Please upload the below to the above application; Drainage Engineers further comments.

Comments in red below (I note the revised drawings are contained within the technical report);
I look forward to receiving revised drawings, etc. Please provide revised drawings separate to the report.

Paul Cann
Principal Drainage Engineer
Engineering Services

PERMEABLE BLOCK PAVING CAR PARK DETAIL
(Scale 1:20)

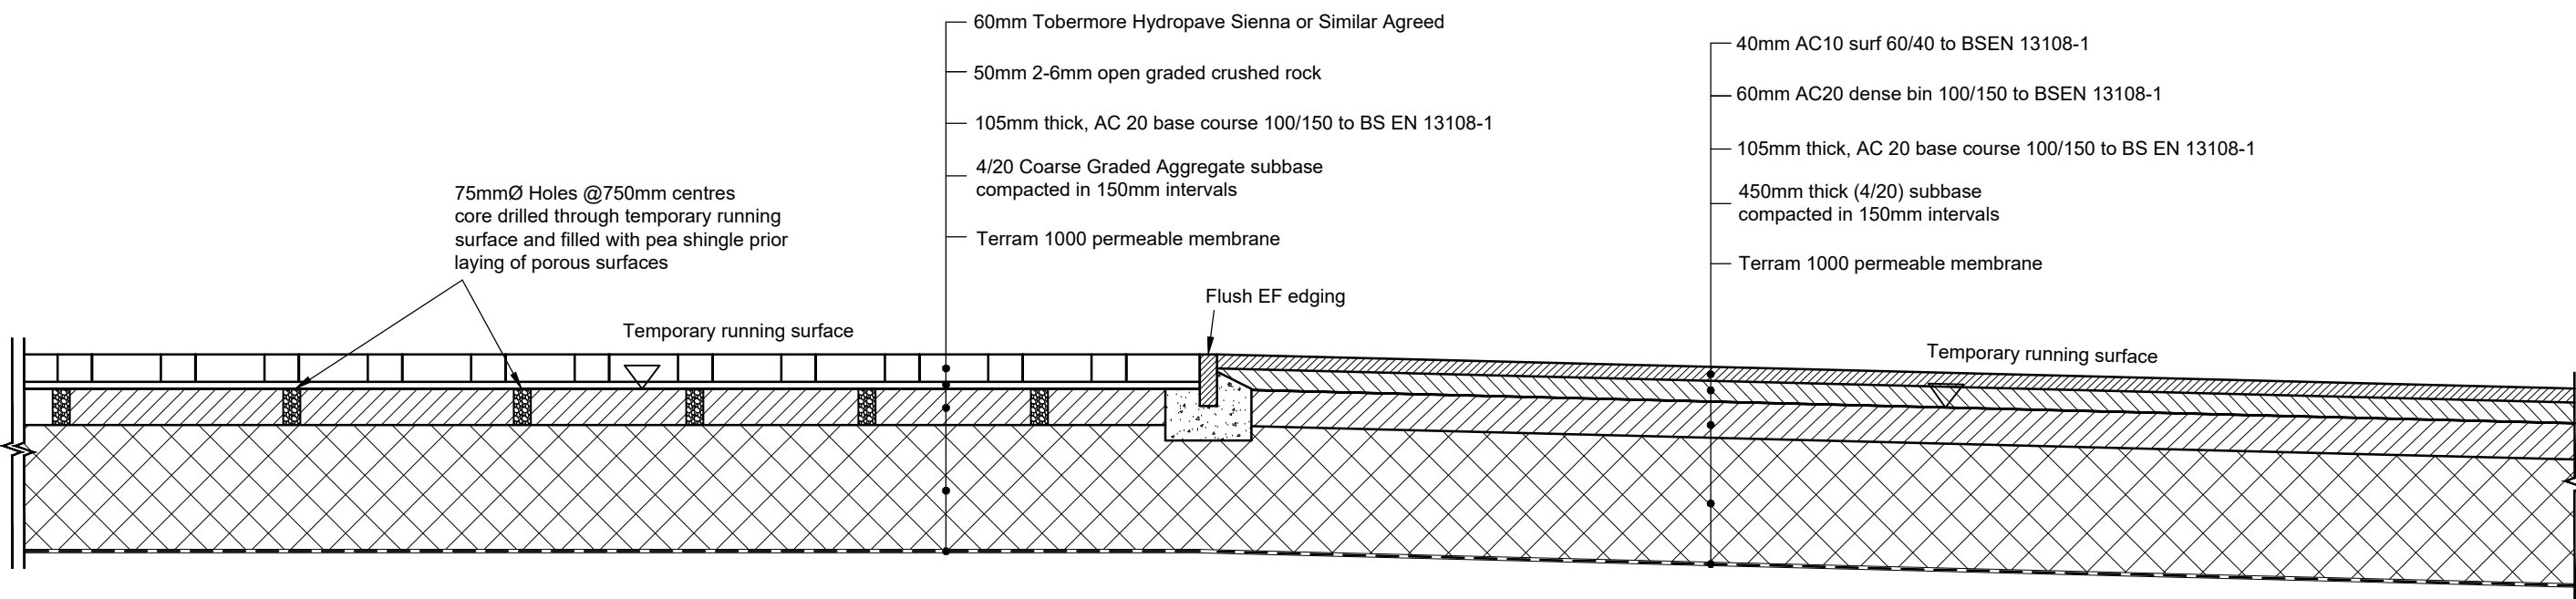
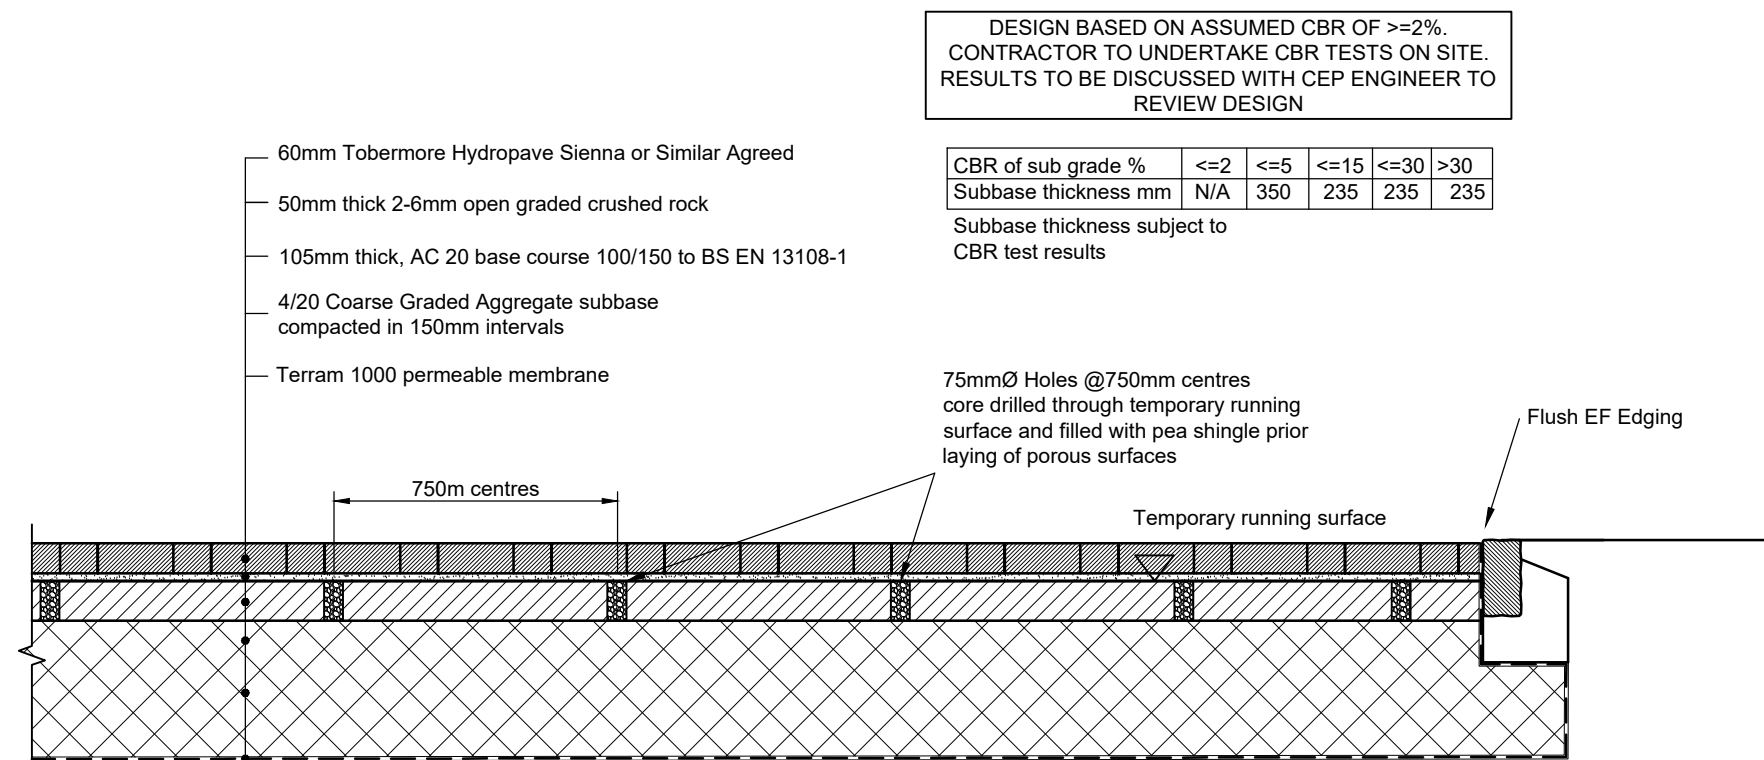
- 4) This is again a design preference. This is fundamental in ensuring that the risk of silt entering the diffuser unit is minimised, is good practice and provides a convenient chamber to enable silt removal. We have added silt traps upstream of diffusers in this instance, however diffuser units are only receiving roof water and any silt / sediment. Any loose sediments or fines are likely to be very low and unlikely to be significant enough to restrict performance of the diffuser units however we have determined in this case they are of benefit. It is surprising how much silt can be produced from a roof, especially when moss's etc become established on the tiles over time. Please add sump depth (min. 300mm) to construction detail.

- 6) Added. ok
- 7) Added where required. ok
- 8) This is a design preference. We have not shown this as there no practical reason or benefit in doing so. The request would require laying asphalt directly onto the permeable membrane during the construction process. The contractor will need to ensure that no fines enter the sub base during the laying of the base course.

- 9) The subbase thickness is dependent on the CBR values and not on the subbase thickness as demonstrated within the supporting calculations and information shown on drawings. Subbase thickness is based on an assumed CBR of 2-5% requiring minimum 350mm of subbase, storage requirements for the infiltration system for a critical 1 in 100 plus 40% climate change storm is a 240mm depth of subbase. ok

CLIENT		Mr Pete Mountford	
PROJECT		Repture Yapton West Sussex	
TITLE		Proposed Layout Drainage Strategy Plan	
DRAWN	DATE	PROJECT NO.	
M Pacifico	Nov 2019	2326	
ENGINEER	CHECKED	DWG NO.	REV.
M Kempshall	SRM	101	B
SCALE	1:200 @ A3

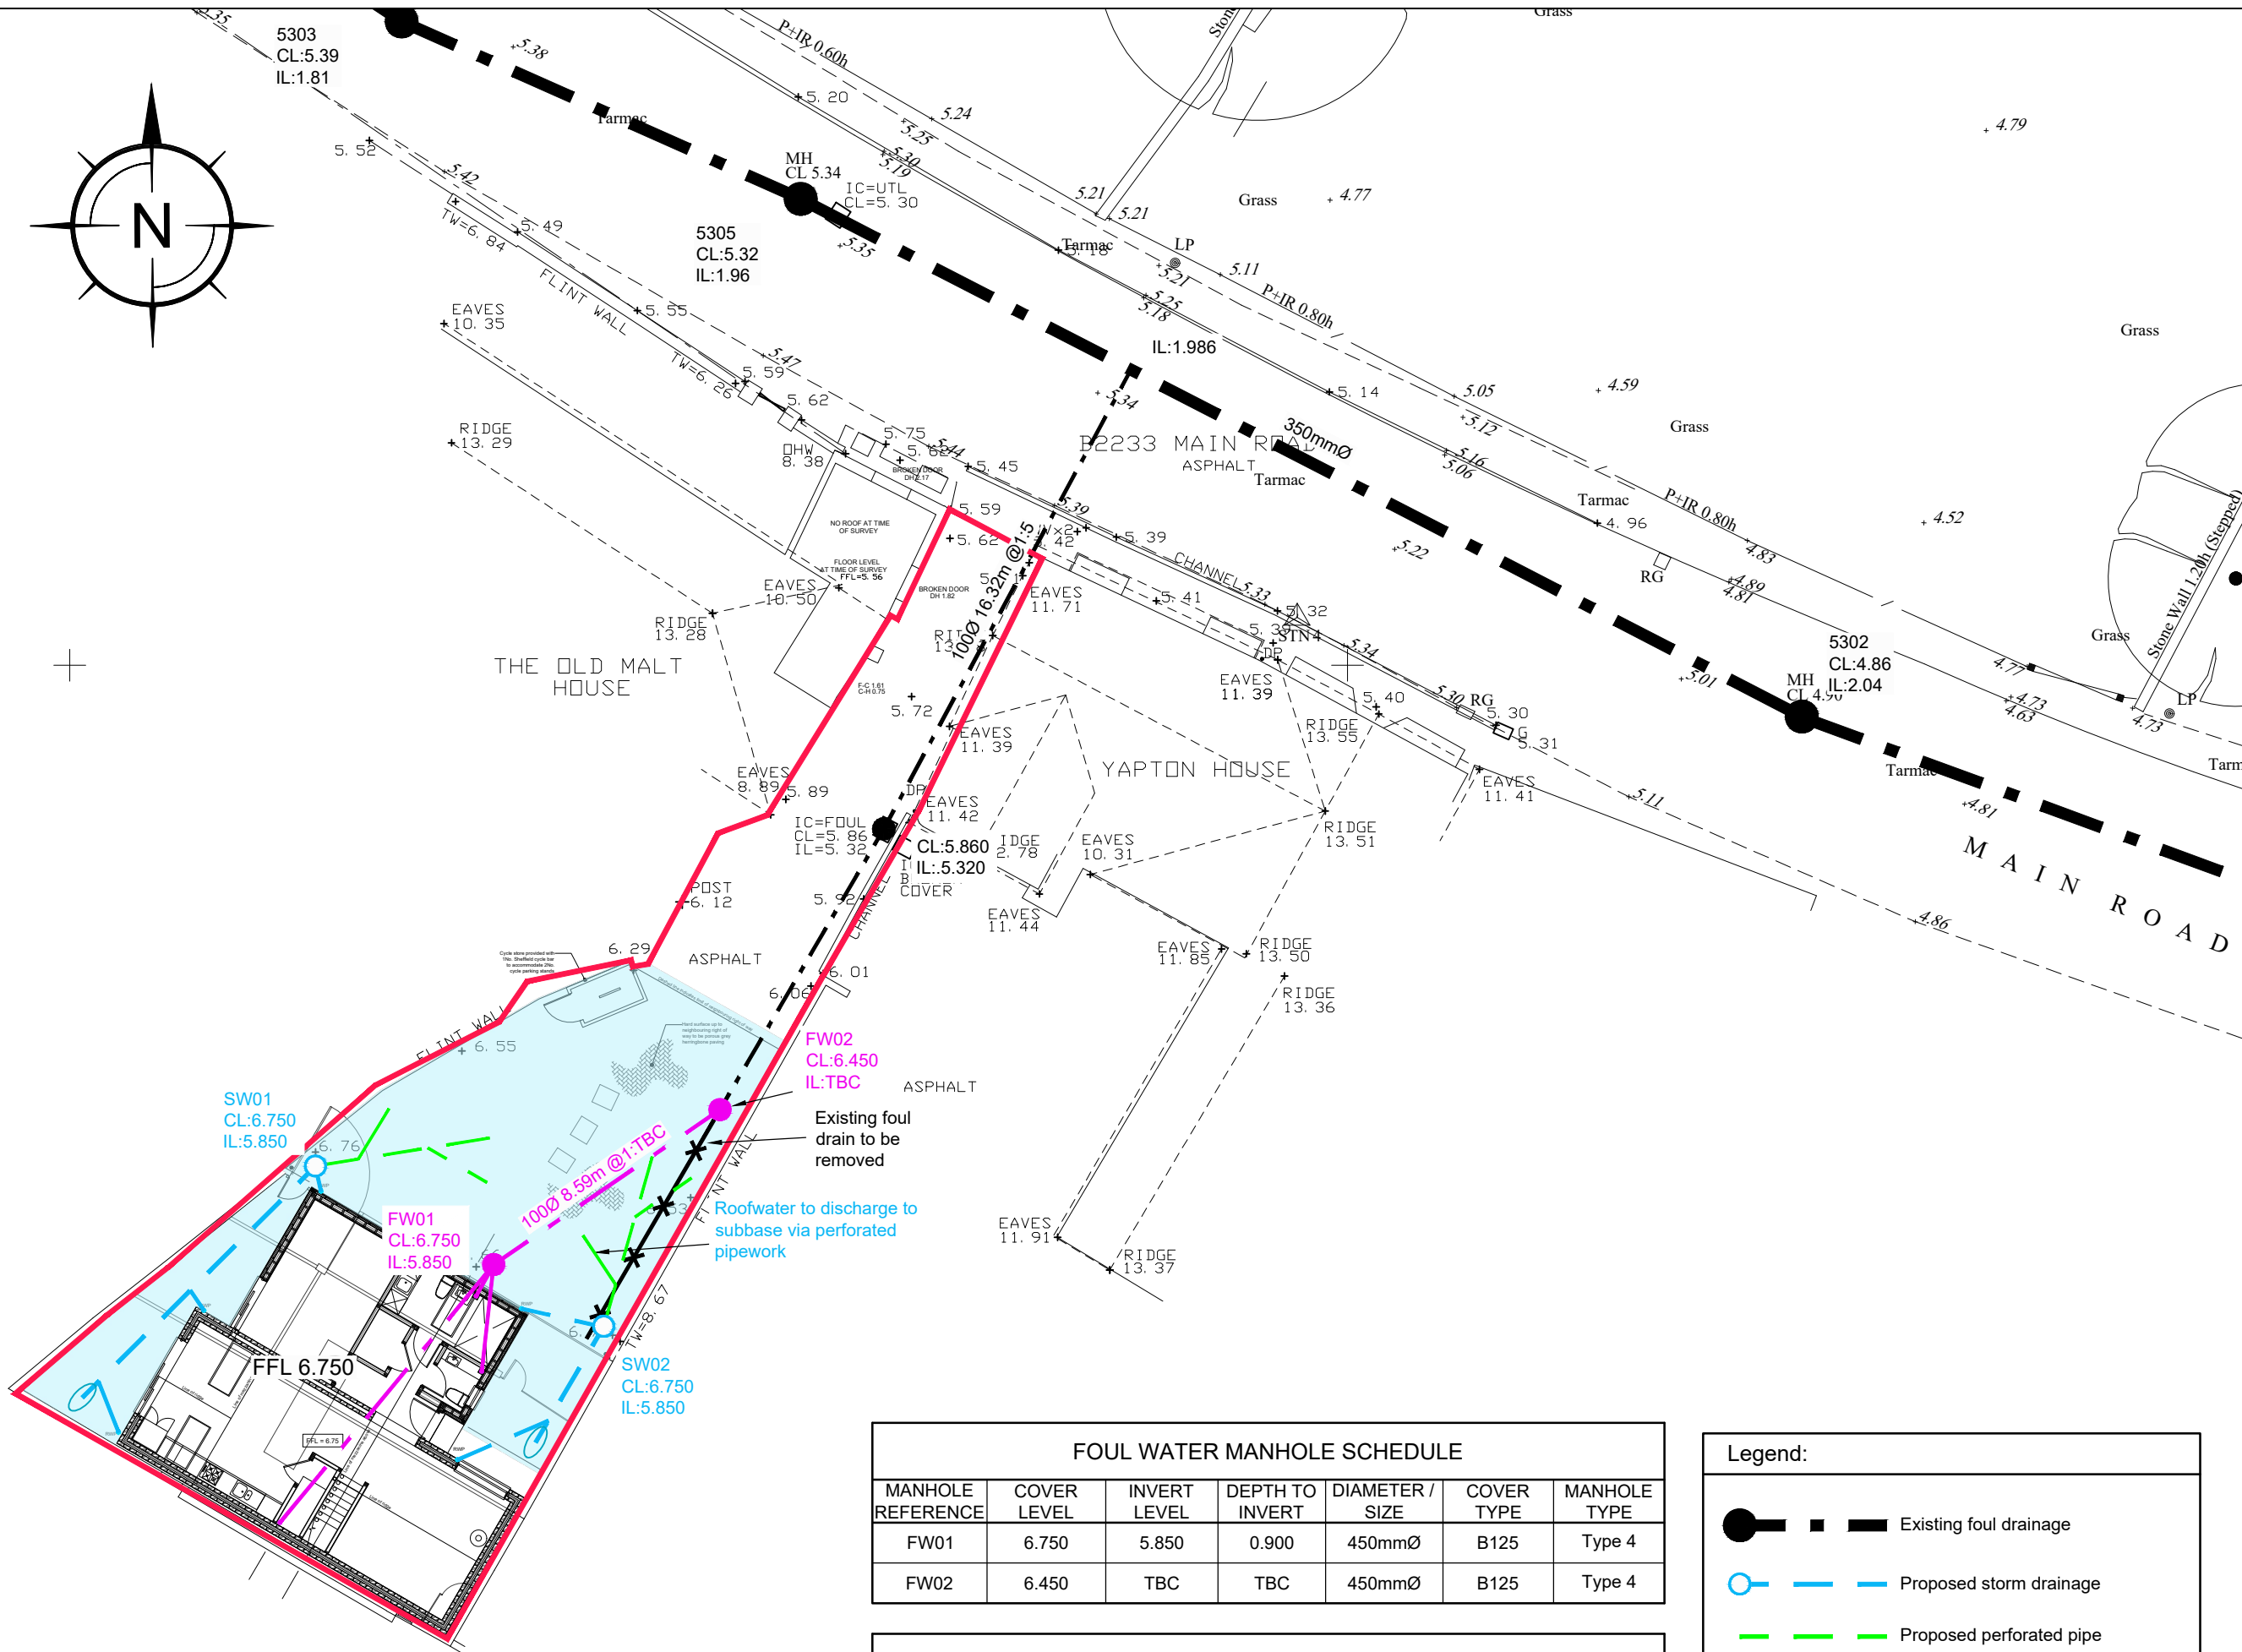
- 2) The extent of the proposed new paving is shown on the drawings which is reflected in the areas of the infiltration blanket within the supporting calculations. The drainage strategy plan, attached again for quick reference, shows no surface treatment changes to the Northern end of the site. The blue shaded area is the area subject to resurfacing. Noted

- 5) Added where not shown – The foul water pipe connecting proposed FW01 and FW02 will not be known until construction and the minimum fall has been stated. Specify pipe diameter and gradient between catchpits and

diffuser units. Also indicate pipe invert level/finished paving level at connection to diffuser unit – to show that the pipe can be suitably connected based upon the proposed construction depth of the permeable paving.

- 10) Additional levels added and subbase thickness updated to reflect the assumed CBR. There is a significant slope on the permeable paving formation level, based upon the finished surface levels provided. The calculations will need to take account of this slope, to ensure that the 1 in 100 year event + 40% is contained within the structure. There is no parameters shown in the calculations to suggest that the slope has been accounted for.
